**Our Case Number: ABP-316051-23**

**Re:** Renewable energy development comprising 9 no. wind turbines and associated infrastructure.  
Umma More and adjacent townlands, County Westmeath.

Our Ref: SID-WM-2023-007

**Proposed Strategic Infrastructure Development (SID):** i. 9 No. wind turbines with an overall ground-to-blade tip height of 185 metres; a rotor blade diameter of 162 metres; and hub height of 104 metres, and associated foundations and hard standing areas; ii. A thirty-year operational life from the date of full commissioning of the wind farm and subsequent decommissioning; iii. A meteorological mast with a height of 30 metres, and associated foundation and hard standing area; iv. Junction accommodation works and temporary access roads to facilitate turbine delivery to an existing entrance on L5363. v. Upgrade of existing entrance on L5363 for provision of site entrance; vi. Upgrade of existing tracks/ roads and provision of new site access roads, junctions and hardstand areas; vii. Underground electrical (33kV) and communications cabling; viii. A temporary construction compound; ix. Spoil Management; x. Site Drainage; xi. Tree Felling; xii. Operational stage site sign

Figure 12-33 Zone of Theoretical Visibility at the Hill of Uisneach.

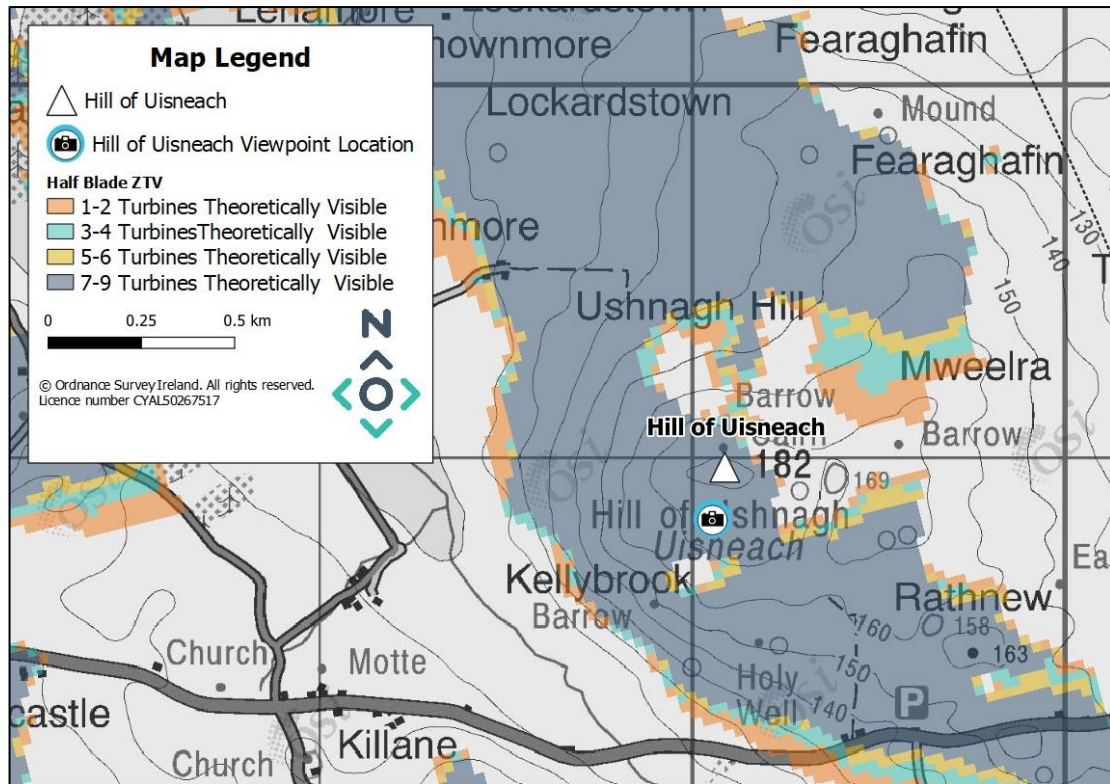
- 2) **Limitations in the Landscape Visual Impact Assessment (LVIA) as carried out:** No photomontages were prepared for views from the Hill of Uisneach and the assessment relies on a digitally rendered wireframe model only. While it is noted that this is the result of circumstances not in the control of the applicant, the Department is concerned that the level of assessment may not be sufficient in the context of the sensitivity of the Hill of Uisneach site and its wider cultural landscape setting.

The Hill of Uisneach was a focal point in the landscape of late prehistoric and early historic Ireland. A key attribute of the monument complex at the site—and central to its potential OUV—is its prominent hilltop location, providing a visual focus for a wider cultural landscape. The panoramic views afforded of this surrounding cultural landscape are important to the authenticity of the site in the present day. It is important that any potential effects to the visual links between the Hill of Uisneach and its cultural hinterland are adequately understood and assessed to ensure that the integrity of this relationship is preserved and protected through informed decision-making.

If Further Information is being requested by the Board, it may be beneficial to consider including clarification of the aforementioned points as part of the request.
